# KITITAS COUNTY

## DEPARTMENT OF PUBLIC WORKS

**TO:** All Staff  
**FROM:** Public Works Plan Review Team  
**DATE:** May 13, 2026  
**SUBJECT:** SP-26-00003 Miller

MILLER SHORT PLAT		
PREPARED FOR DON MILLER		
A PORTION OF SECTION 4 & SECTION 33, TWN. 19 N., RGE. 15 E. & TWN. 20 N., RGE 15 E., W.M.		
KITTITAS COUNTY WASHINGTON		
DWN BY <b>G.W.</b>	DATE <b>04/2026</b>	JOB NO. <b>230053</b>
CHKD BY <b>D.L.P.</b>	SCALE <b>1" = 200'</b>	SHEET <b>2 OF 3</b>

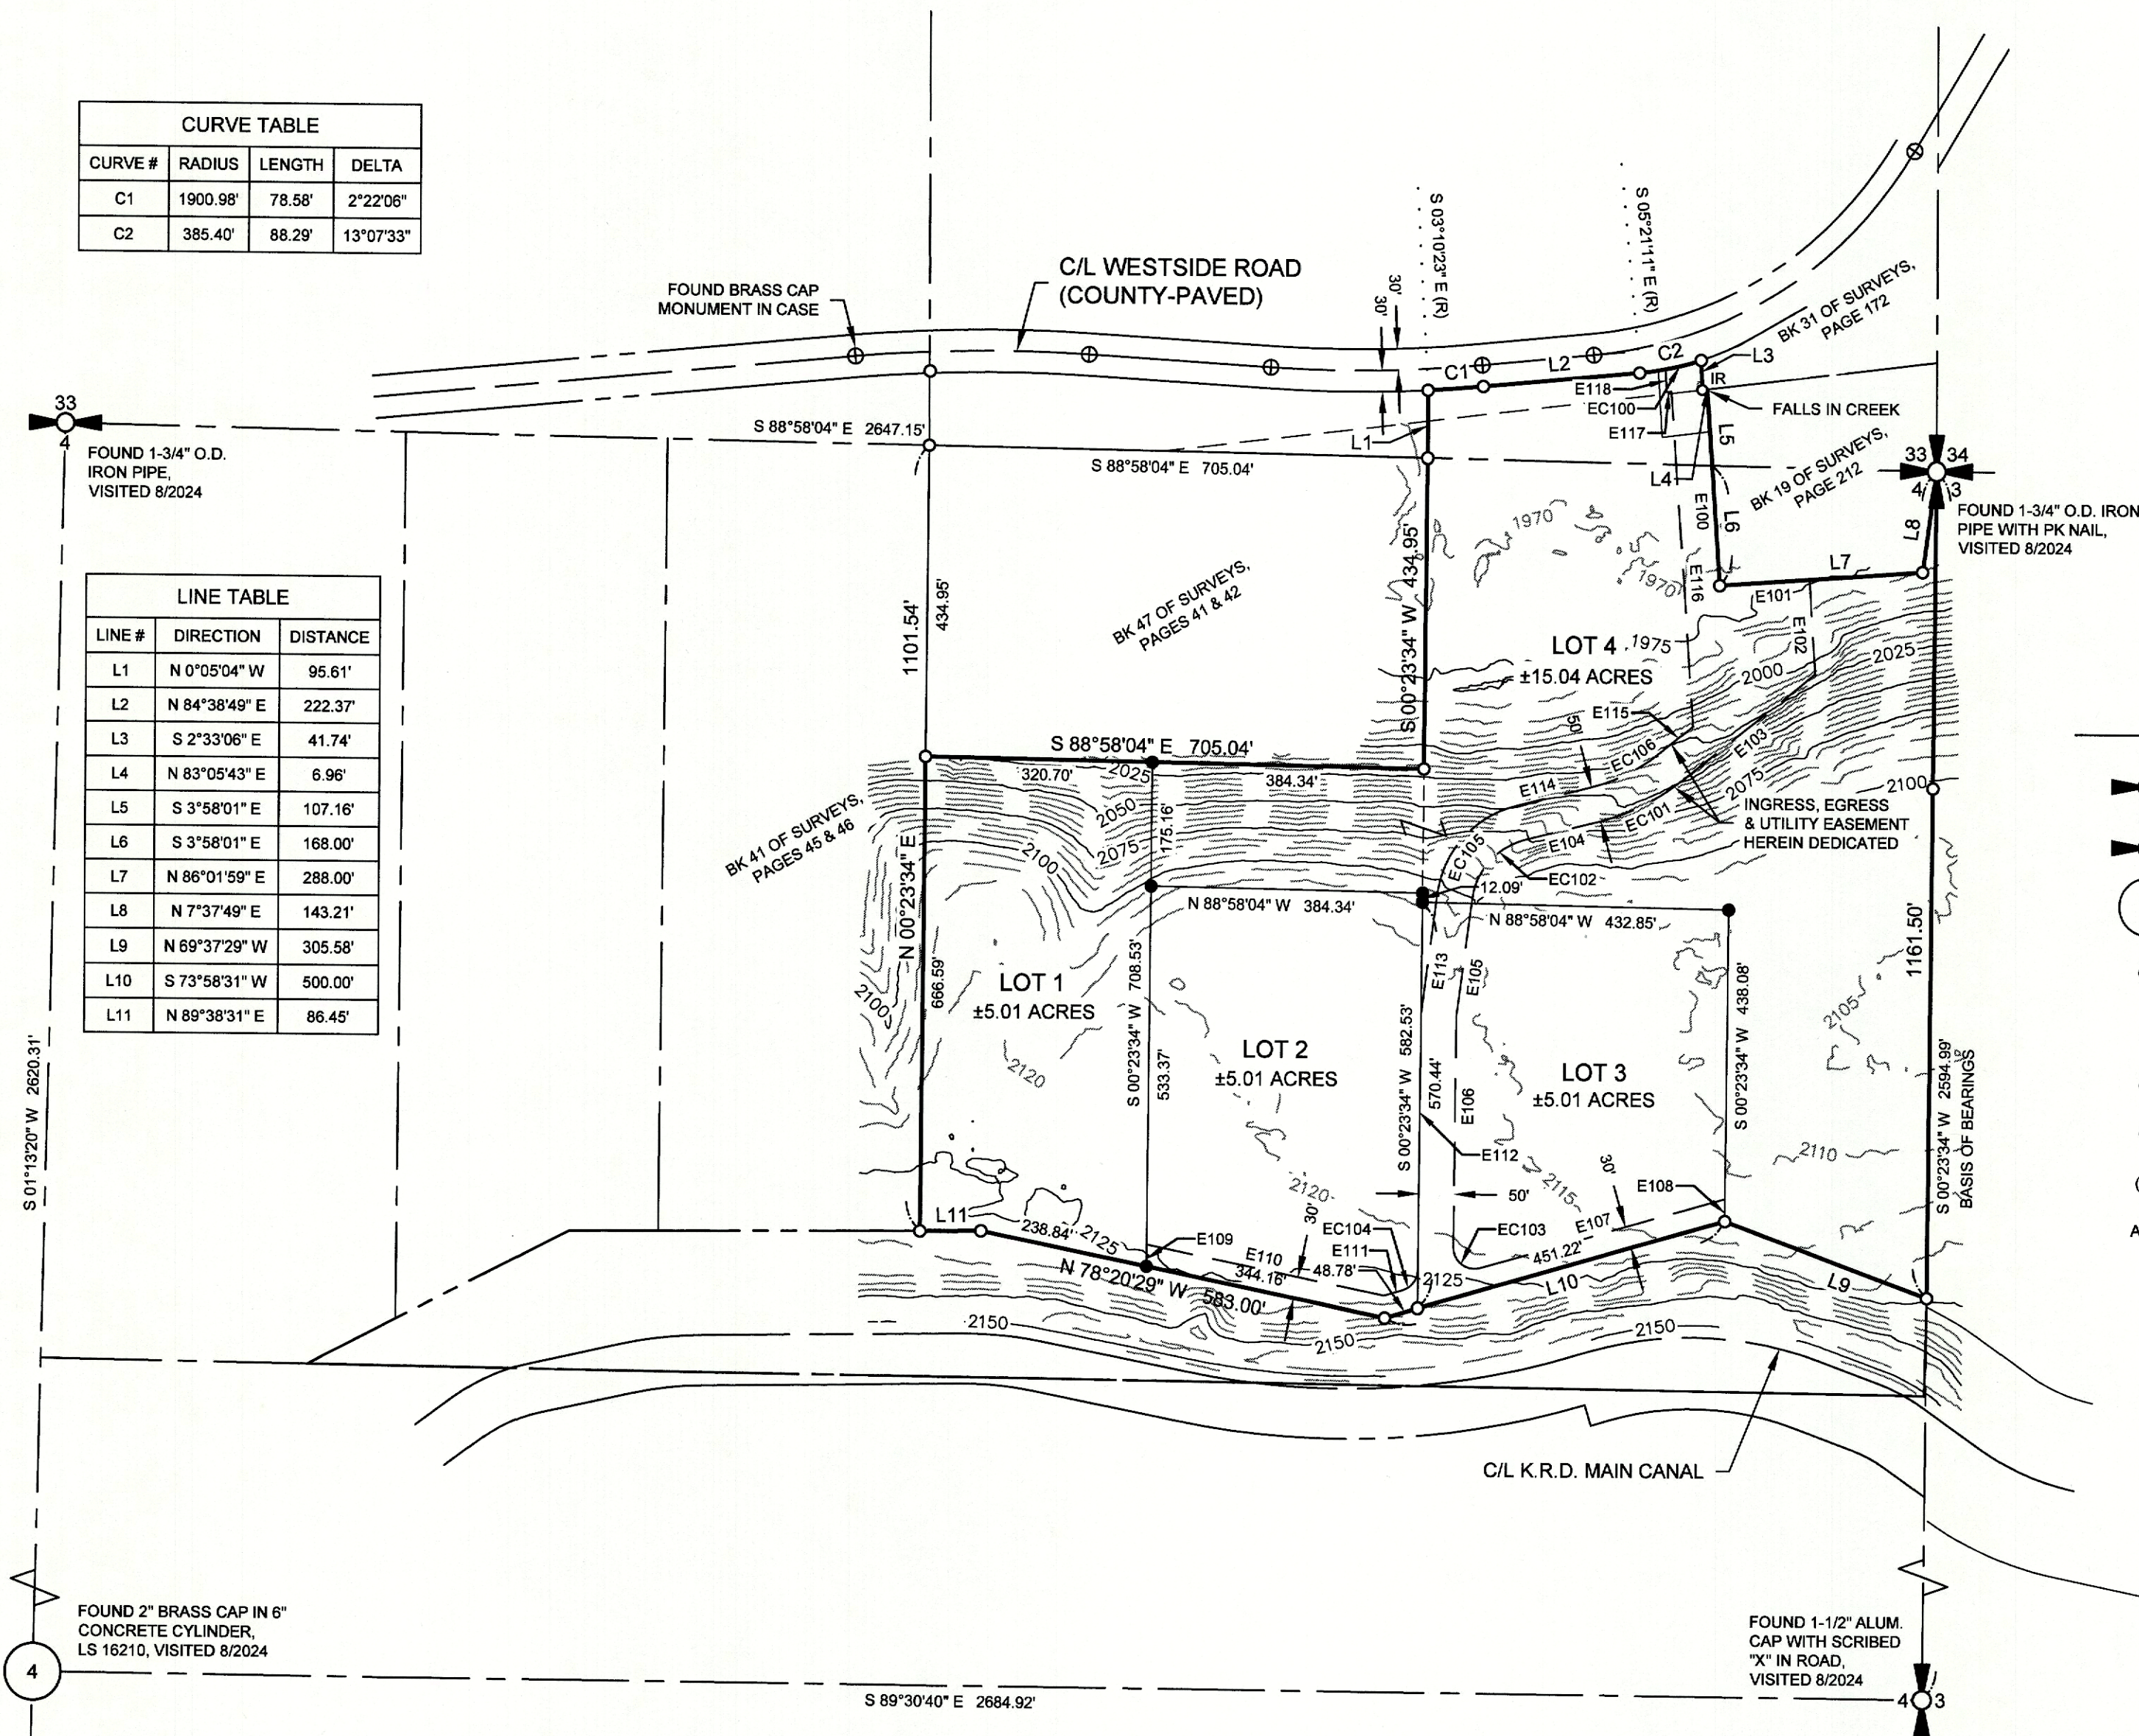
<b>SURVEY</b>	<ol style="list-style-type: none"> <li>1. Application map does not meet requirements of WAC 332-130-145 Topo Standards.</li> <li>2. If any road monuments or either of the 2 untied property corners were utilized for survey control, please include distance and bearing ties to these monuments.</li> </ol> <p>OF NOTE (change not required for approval)</p> <ol style="list-style-type: none"> <li>1. The area near the N'most corner of Lot 4 would benefit from a note "See Detail Next Sheet". (JT)</li> </ol>
<b>TRANSPORTATION CONCURRENCY</b>	<p>Transportation concurrency not applicable to this project.</p>
